October 28th, 2020
DRB Review of Poole Property Site Plan

Dear DRB Board members,

SITE PLAN

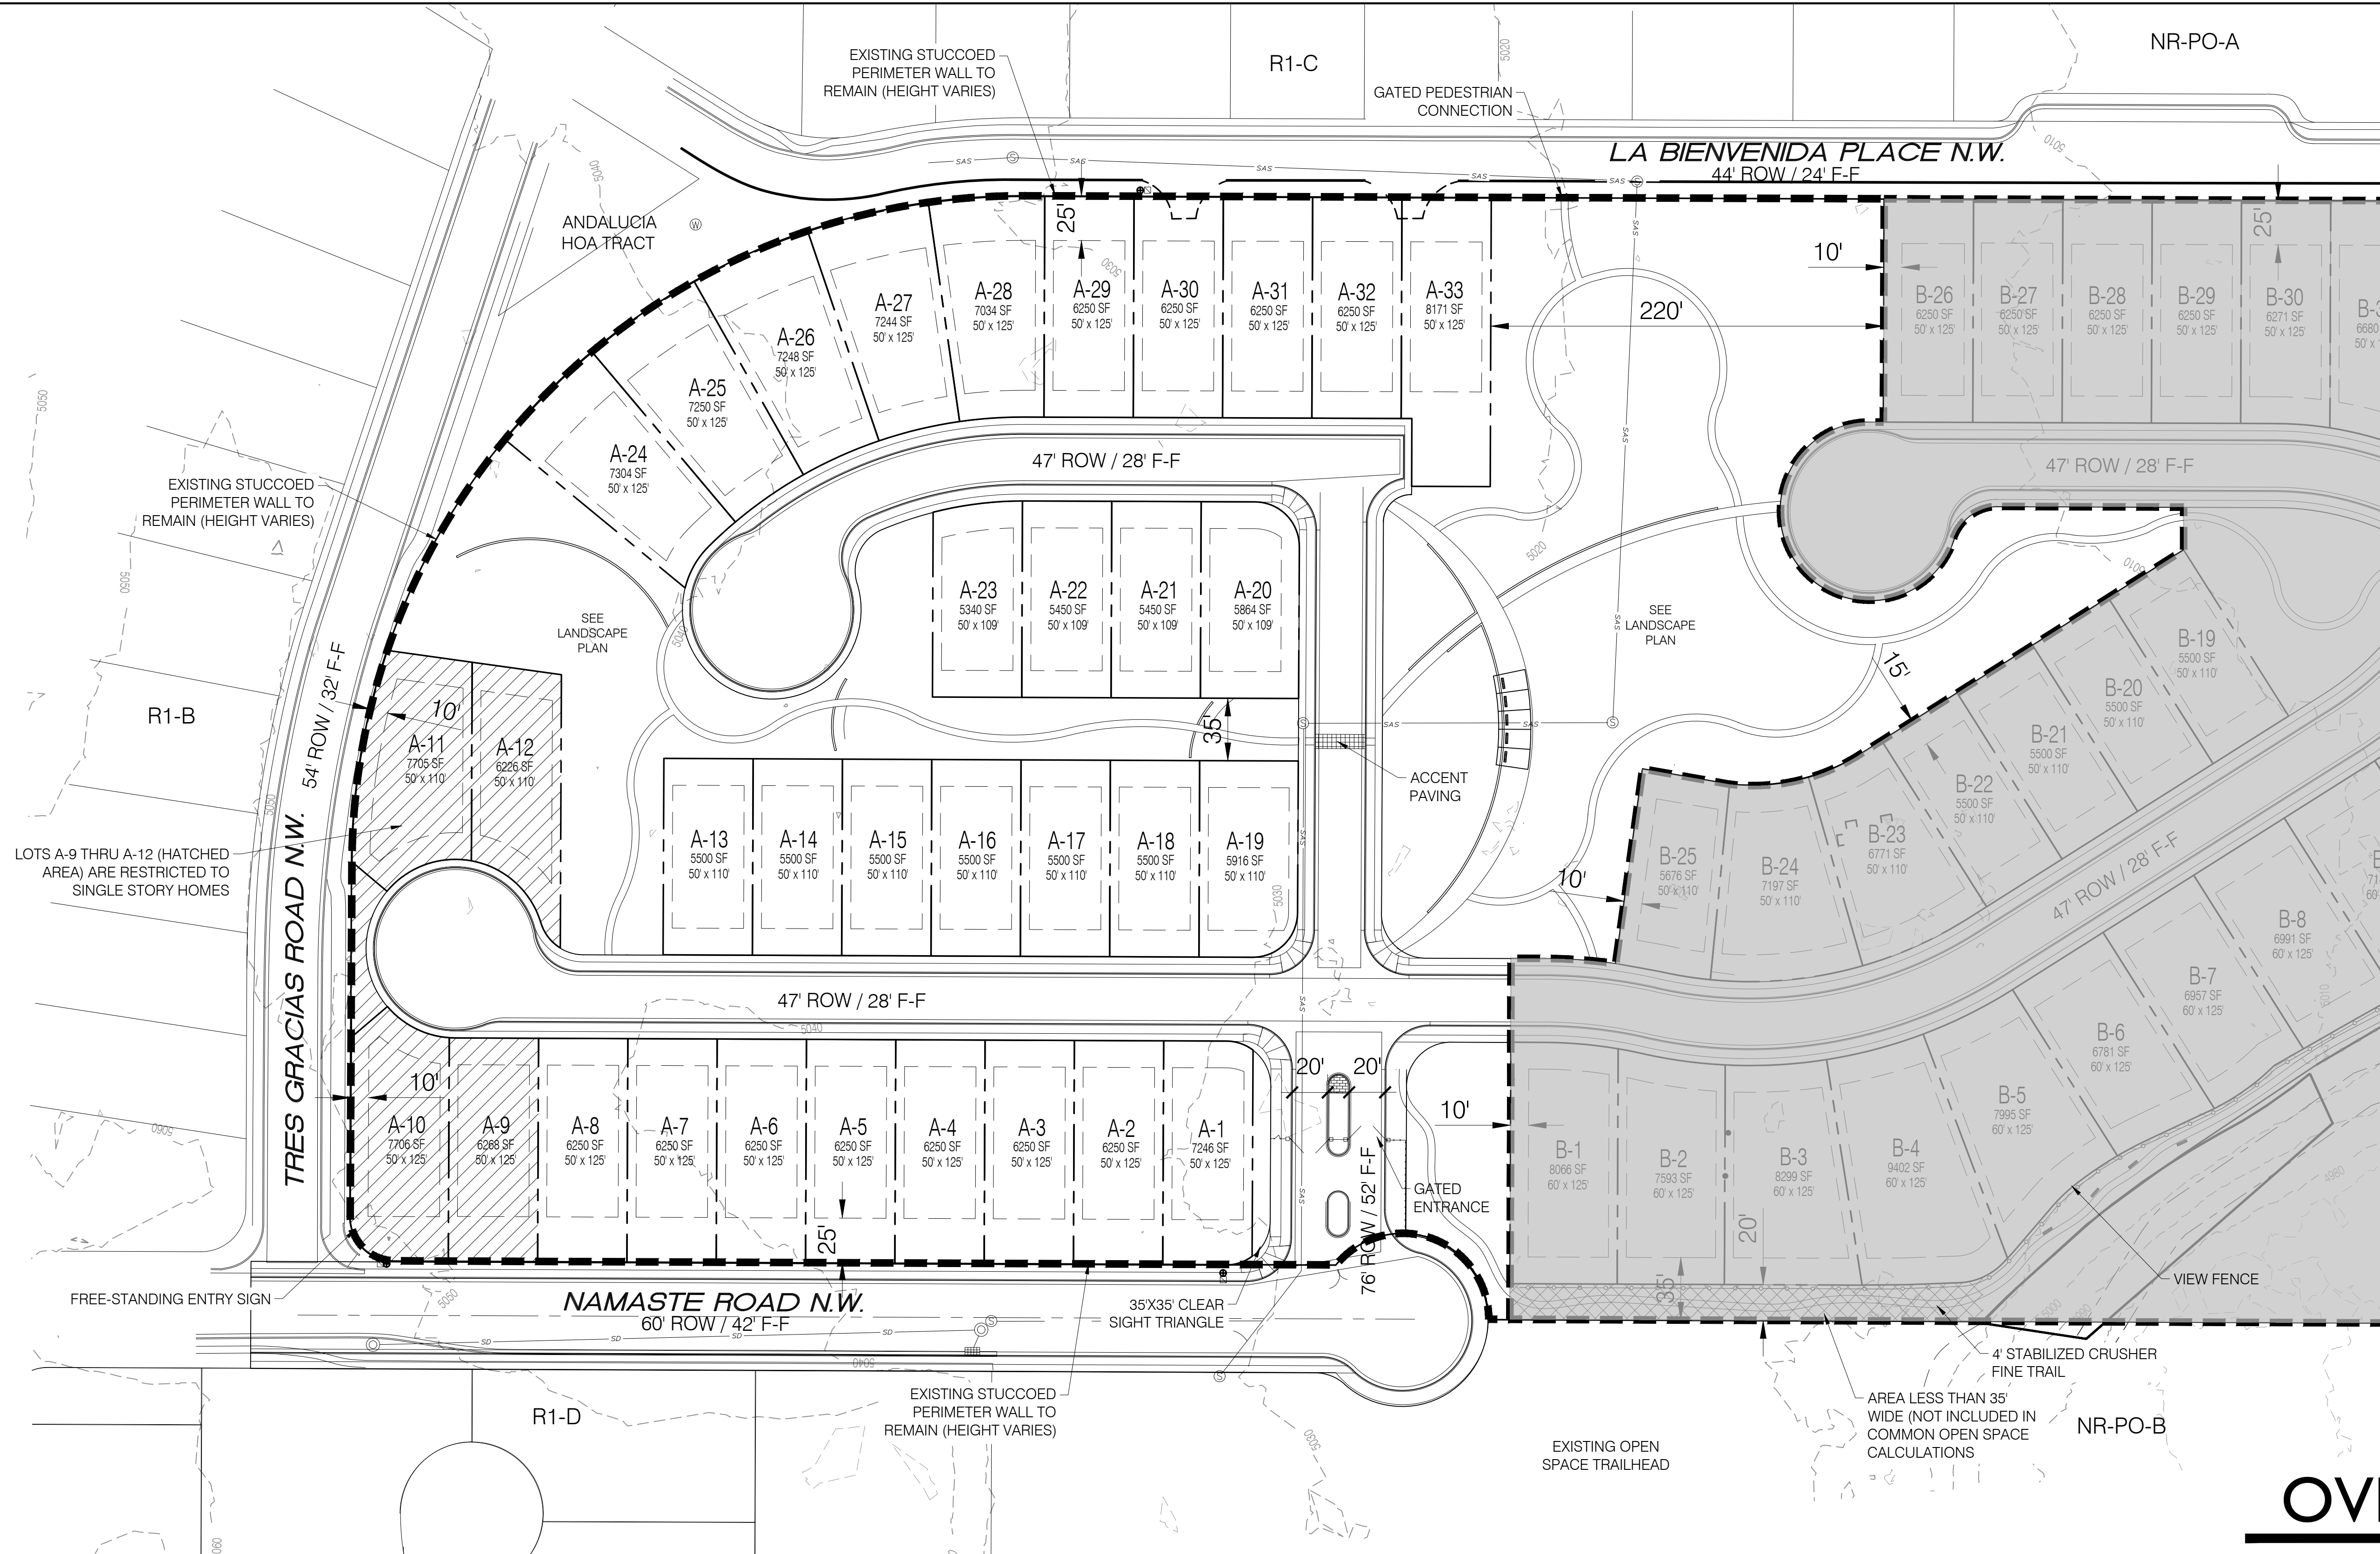
1. Setback/Buffer protection along Sandy bluff: The Hydrologist, the Open Space Superintendent, and members of the public has consistently expressed concerns of not having enough Buffer protection along the sandy bluff. In reviewing the site plan drawings attached to the DRB agenda, the drawings show the steep slopes, the detention pond & the wetland (both floodways), and the flood fringed areas of the bosque on the eastern portion of the site. They all need more buffer protection between the homes and the wetland and Bosque areas. The buffer shown on the eastern portion of the site plan is not adequate to protect the wetland, nor the homes from environmental impacts, such as soil erosion, storm water drainage, Bosque fires, wildlife conflicts, mosquitoes, domestic chemical use etc. Please see Open Space, and public comments below:

The development's design has very dense housing right up to the edge of the bluff above the Oxbow and a development of this density will inevitably lead to encroachments into and possible contamination of the Oxbow.

Development, in the form of structures and buildings, should be located as far away possible from the MPOS and any adjacent slopes to provide buffer to the wildlife habitat below the bluff and to prevent erosion and subsidence of the land above the MPOS.

CONCEPTUAL GRADING AND DRAINAGE PLAN

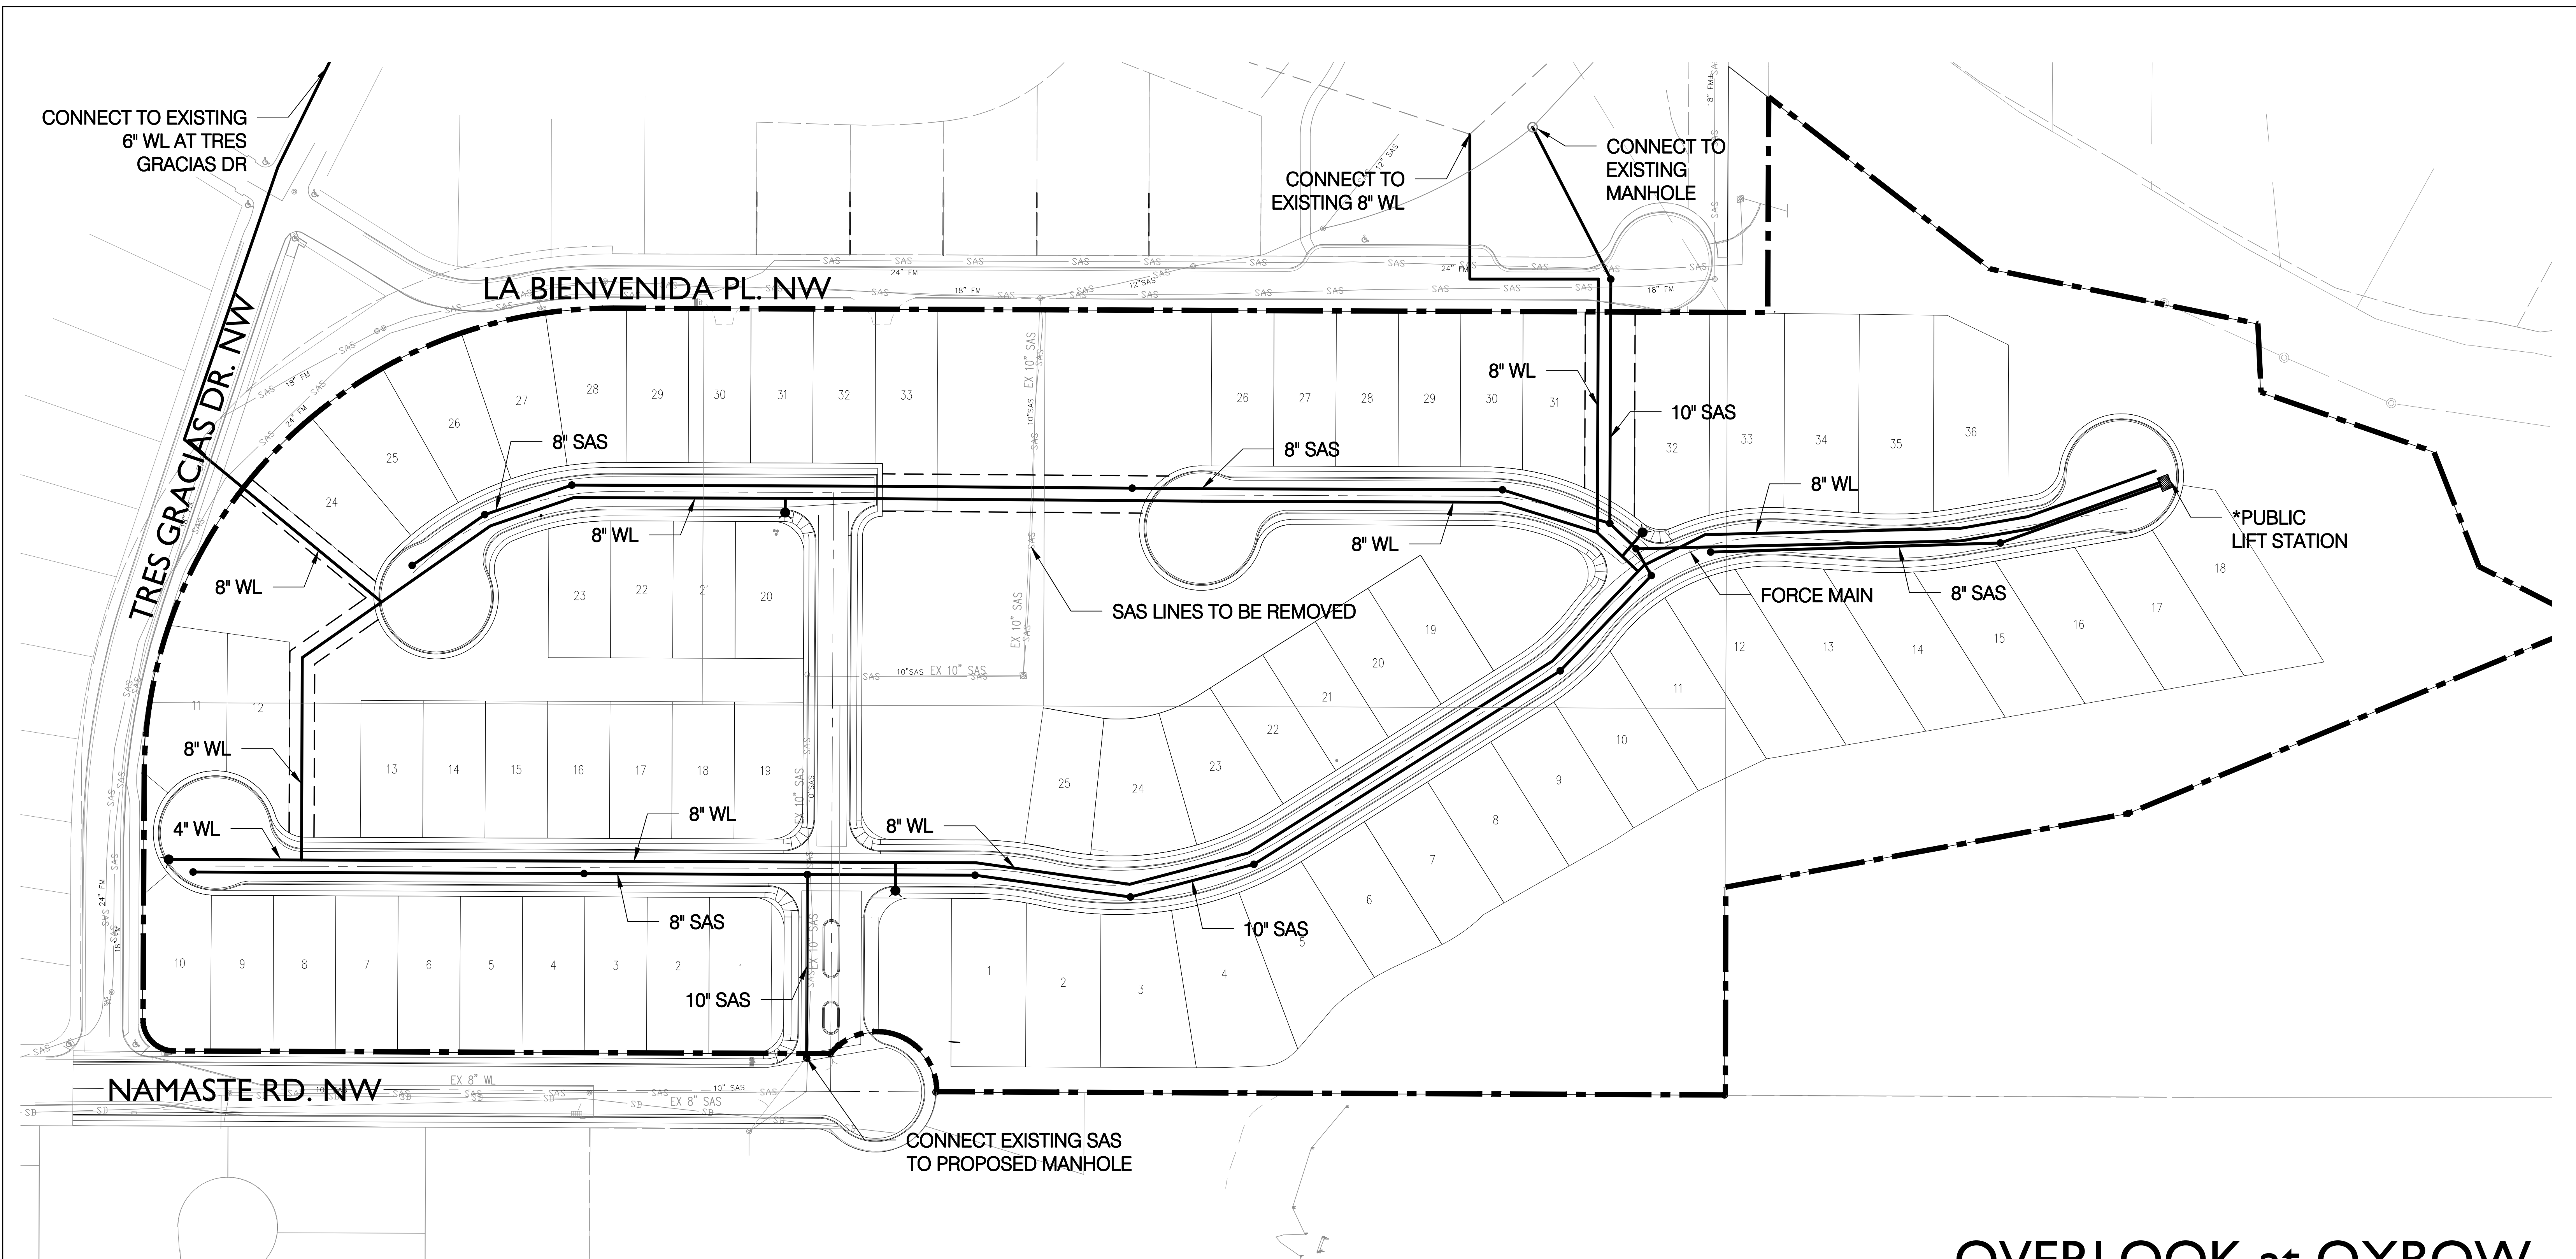
6. When will the AMAFCA regional sediment pond (part of the AMAFCA arroyo system) on the north side of the Property going to be deeded to AMAFCA? Hydrology had commented that: The land containing the AMAFCA facilities in the northeast corner of the site will have to be platted as separate tracts and conveyed to AMAFCA by deed. On page 35 of the March 14th, 2019 Staff Report.

CONCEPTUAL UTILITY PLAN

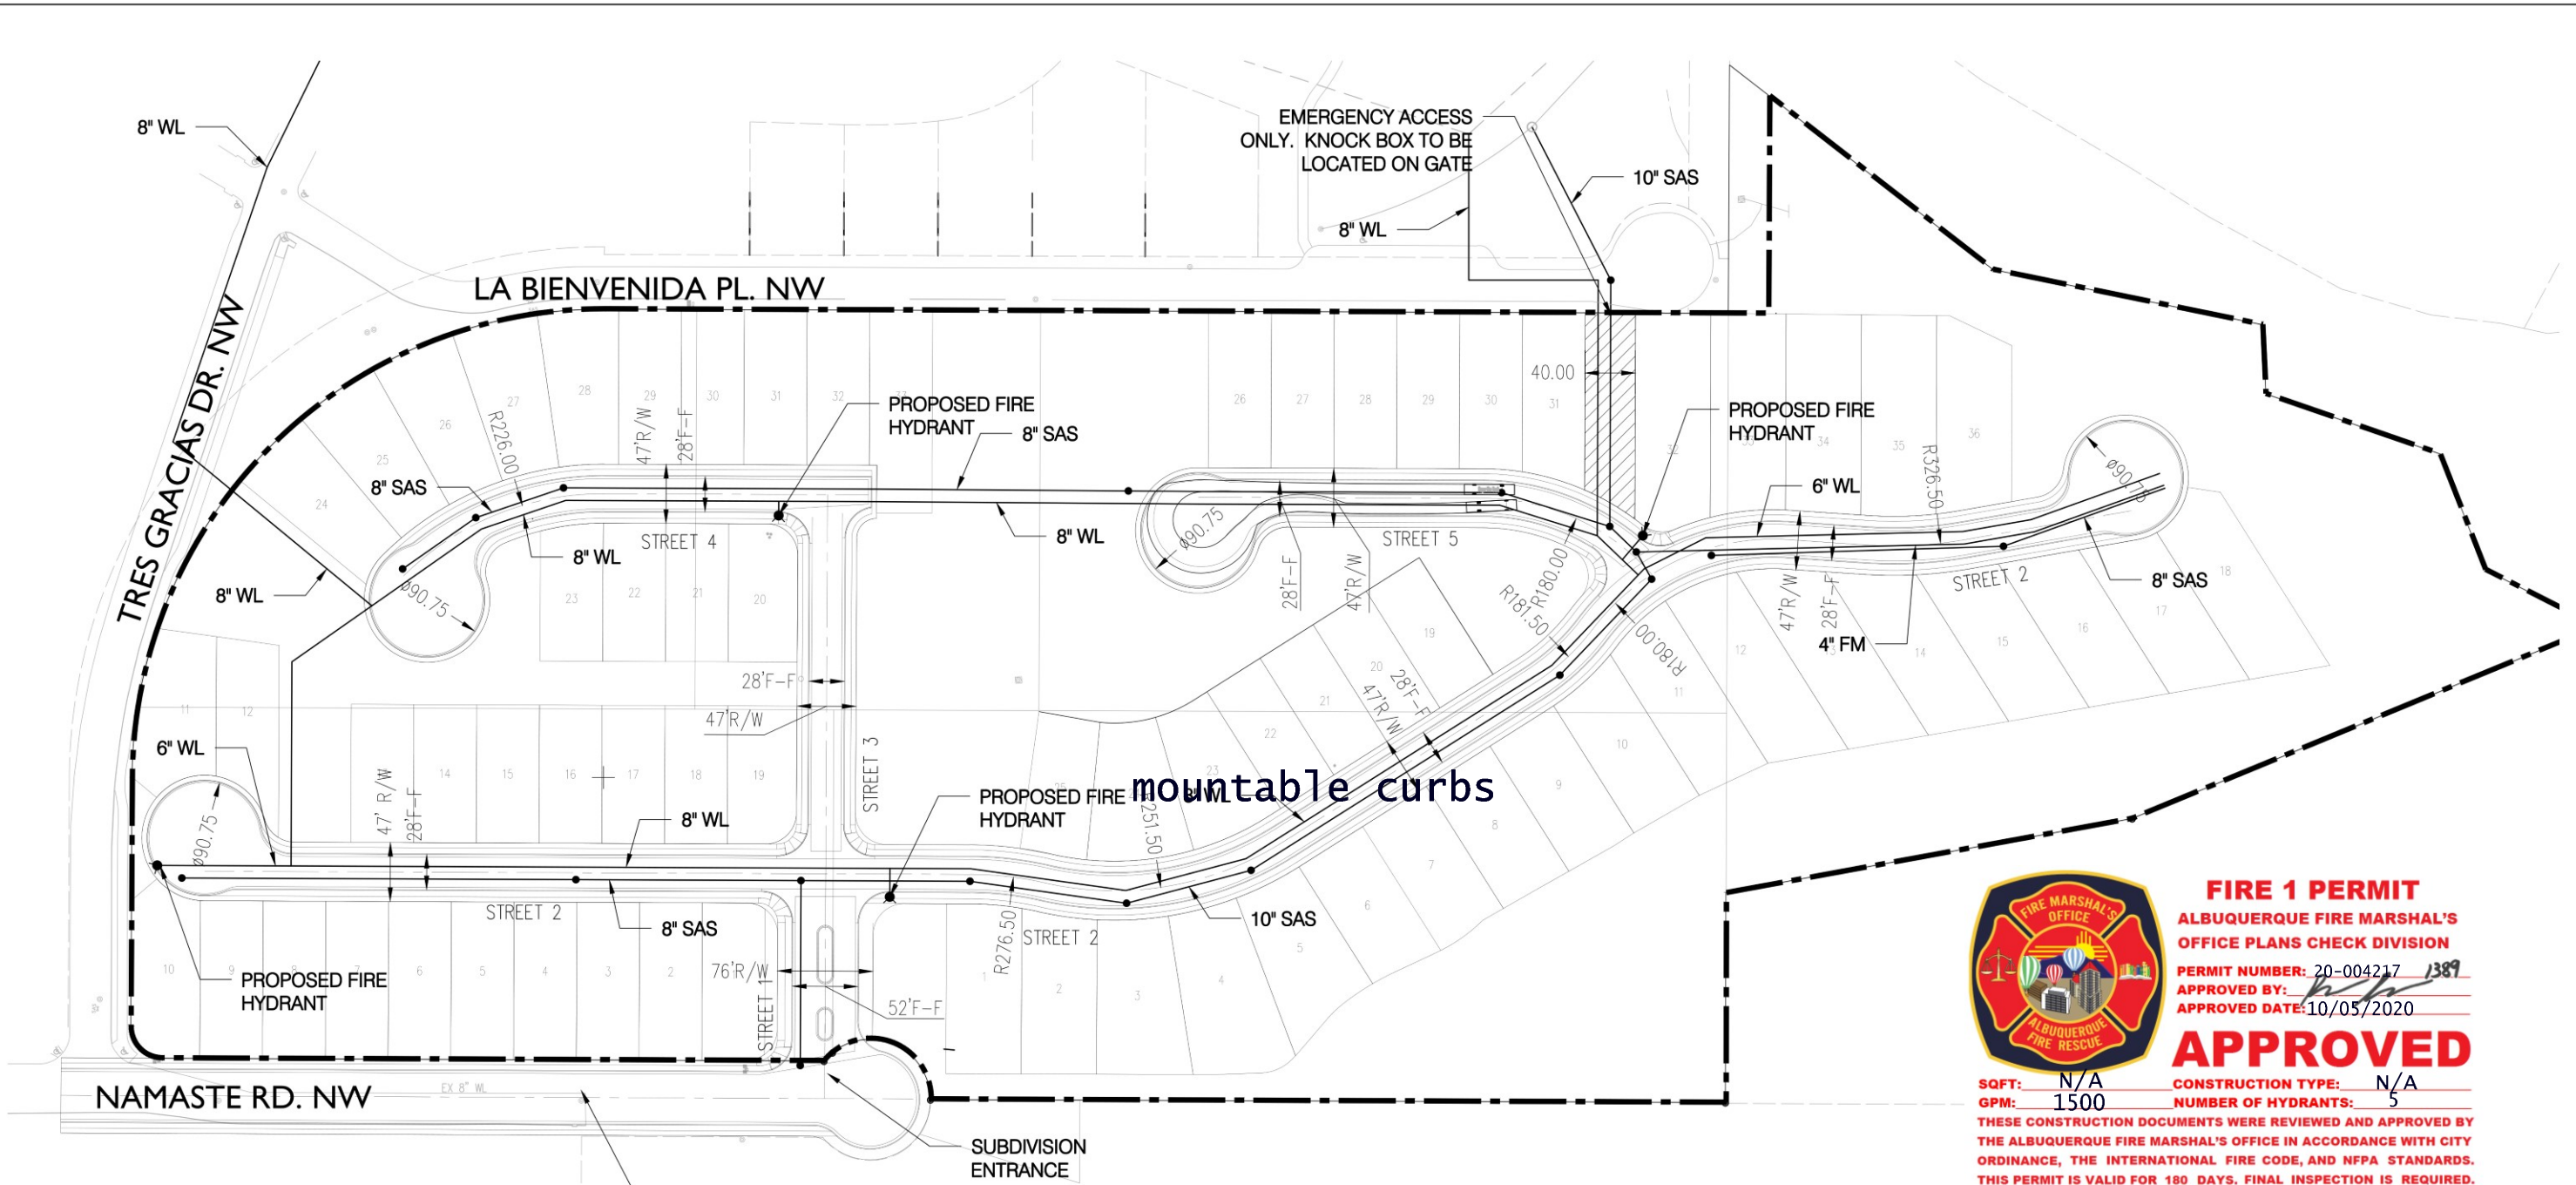
3. I support the elimination of the Force Main sewerage facility: We support the efforts to eliminate the need to do a Force Main system. Concerns have been raised that the gravity fed sewer/pump system has been known to be unreliable, costly and problematic. See Norm Guame's comments below:

.... a small buried lift station would be maintenance intensive and a burden for this developer to place on the public. What reliability features would the ABCWUA require to avoid overflow of sewage or back-up of sewage into homes in the event of a pump failure or power failure?

As a retired licensed engineer with expertise in wastewater collection and treatment, it is my professional opinion that such a buried sewage pump station located under a street and without above grade features is unsafe, disproportionately costly to operate and maintain. It will be a public nuisance. Norm Gaume February 5, 2018, To Planning Director
